19 December 2019

Our Ref: R/2017/11/J
File No: 2019/641761

**Modification 6 SSD 8449 – Changes to Conditions and Heritage Glazing
2 Locomotive Street, Eveleigh**

Figure 3 | Heritage arched window – external view (left) and internal view (right)

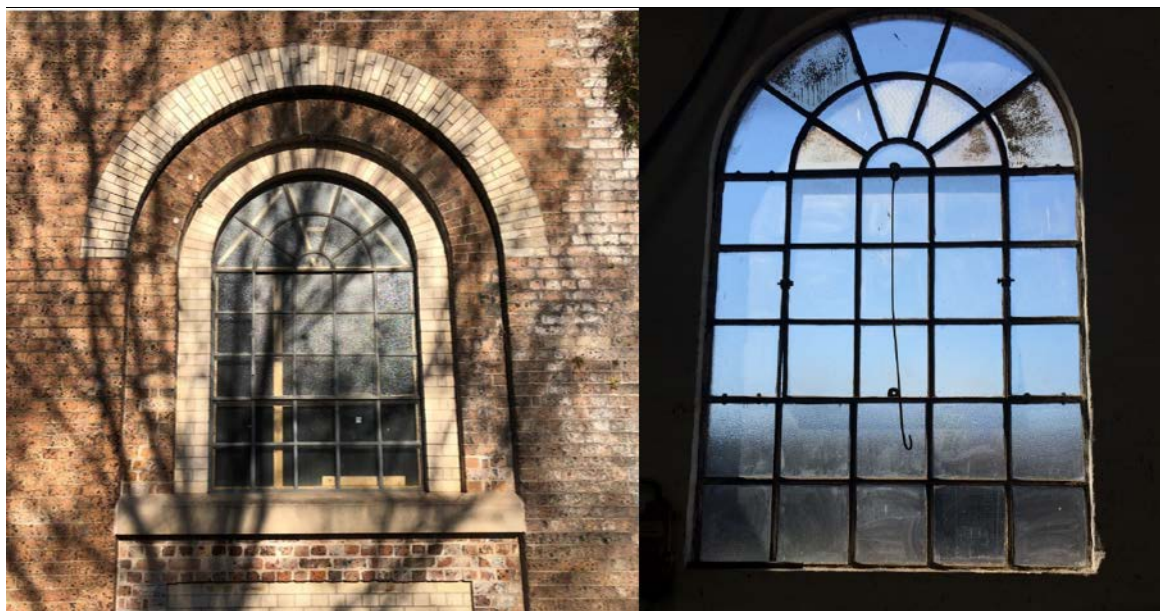
The City concurs that the wording of the condition should be amended to facilitate the replacement of existing glass. However, the proposed terms 'opaque' and 'tinted' do not best correlate with the type of glass to be replaced.

To ensure that a like for like replacement of elements is implemented, it is recommended that the condition be amended to incorporate the term 'frosted', which best corresponds with the type of glass of the existing windows. A suggested re-wording of the condition is put forward for consideration as follows:

All new external glazing used for the Locomotive Workshop is to be clear. Frosted glazing is only permitted in existing heritage arched windows to match like for like with the surrounding frosted glazing within the same windows.
